22 December 2022

Director Energy Assessment, Planning & Assessment  
Department of Planning & Environment Locked Bag 5022  
Parramatta, NSW 2124

**Subject: SSD – 10387 – Daroobalgie Solar Farm Response to Submissions**

Figure 1.2 Back Yamma Rd/Troubalgie Rd intersection proposed widening (B double movement)

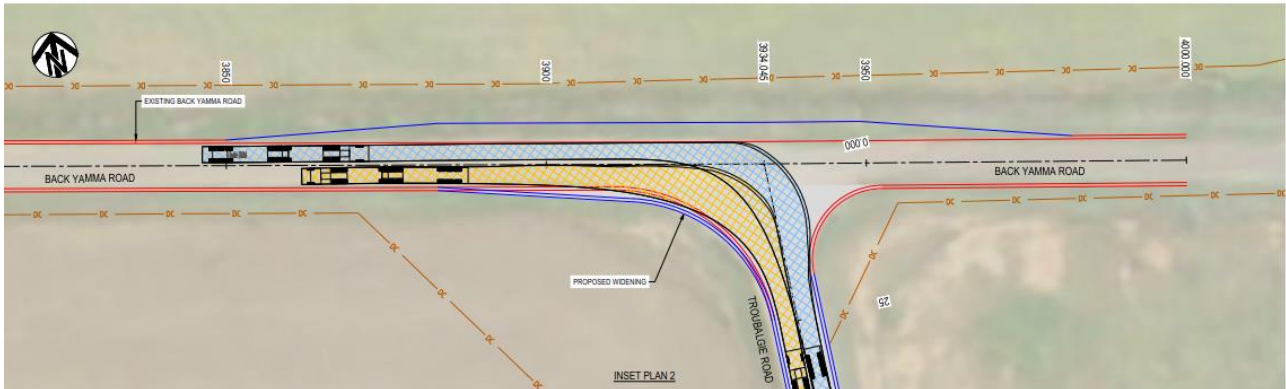
Council is not yet satisfied that the road upgrades have been satisfactorily designed. The low-speed swept paths of the B-Doubles are encroaching significantly into the opposite lane in all locations. Of particular concern is the intersection of Troubalgie Road with Back Yamma Road where a vehicle may be waiting on the hold line on Troubalgie to turn right and get clipped by a turning B-double. There are little details provided in regards to frequency and daily numbers of B-Doubles to assess the exposure of the abovementioned risk. Council therefore requests that the Department include a condition on the development consent with the following intent:

*Prior to the commencement of works, the local roads between the Newell Highway and the construction site are to be upgraded to ensure the largest vehicle associated with the construction of the development can traverse the entire route safely. These upgrades are to be designed in accordance with Austroads Guide to Road Design and the Forbes Shire Council engineering guidelines, in consultation with Forbes Shire Council. In accordance with Section 138 of the Roads Act, all works within the road reserve require a Section 138 approval from Forbes Shire Council as the Roads Authority. This approval is to be obtained prior to the issue of the Construction Certificate.*
